17 May 2021

Our Ref: 2021/216095
File No: R/2017/25/G
Your Ref: SSD-8925-MOD-4

The New Sydney Fish Market – SSD 8925 MOD 4 – Redistribution of Sediment

## **Attachment A: Modified Sediment Reprofiling Extent Provided by Multiplex**

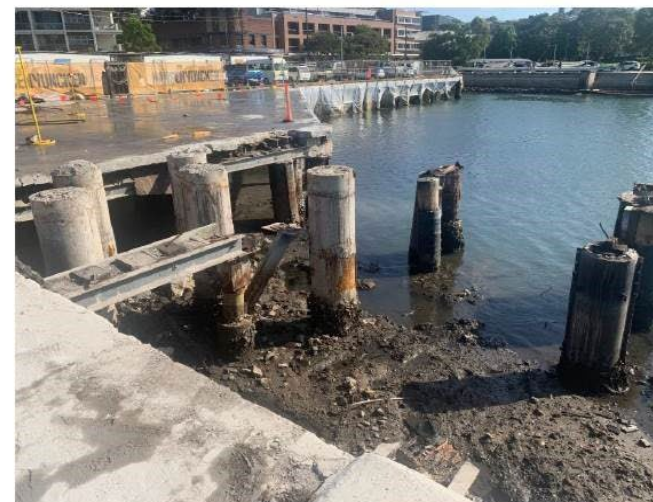
It is requested that the proponent clarify that the proposed increase amount of redistributed sediment from 55m³ to potentially over 12,000m³ and removal of 470m³ of existing rock will result in no material variations to the scope of remediation and/or validation works to be conducted at the site.
